From: Tim Townsend 
Sent: 30 January 2018 14:58
To: Paul Spratt
Cc: Simon Davis
Subject: RE: Sheffield Stand design details

PLAN CYCLE STORE

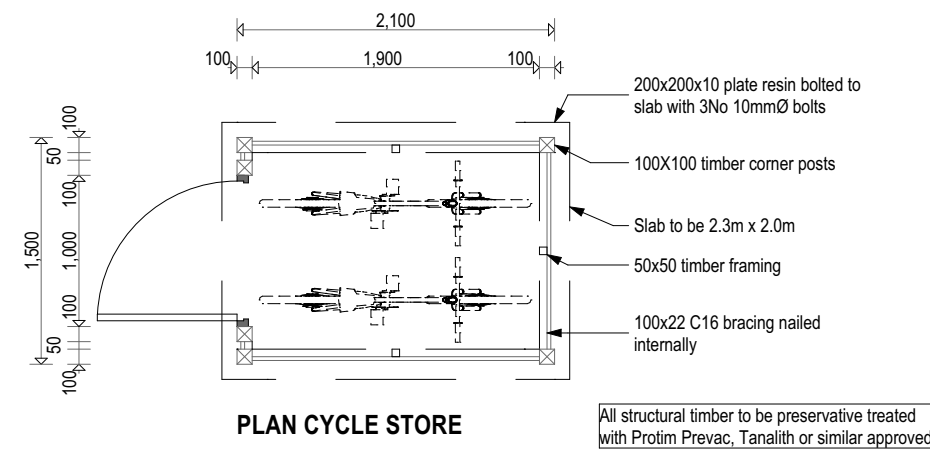
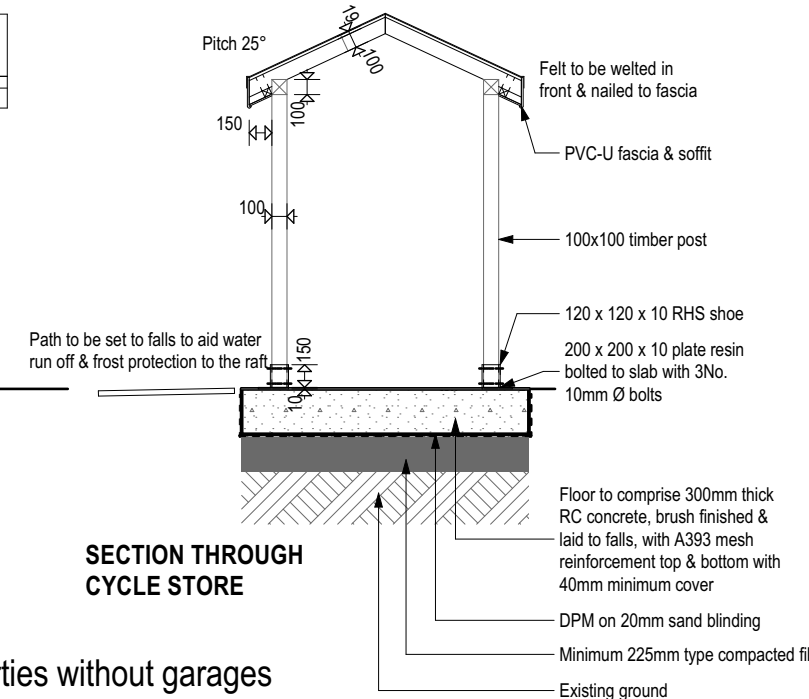
Ideally, I'd say enlarge the cycle store and provide the Sheffield stands. However, if the Planning Case Officer doesn't want it enlarged, a compromise could be considered. So, if Simon wants the building to stay as it is, then on this occasion I will accept the proposal as shown in your option 2 (so half Sheffields and half Neaths). However, if he's happy for it to be made bigger, go for all Sheffields.

Please bear in mind for future schemes that WSCC's normal requirements and preference for Sheffield (or similar) specification will be sought.

Thank you for your email. I have set out the area required to accommodate 12 no cycles when using the Sheffield stands (see red line) and overlaid it upon the layout containing the Neath cycle stands.

You will note that the cycle store will increase by 1.375m x 0.95m (see blue dimensions).

1. Make the cycle store bigger to accommodate the Sheffield stands.
2. Reach a compromise where we use 6 no Neath and 6 no Sheffield stands with a spacing as set out in the attached spec sheet and shown in option 2.
3. Stick with the design as proposed using the Neath stands.
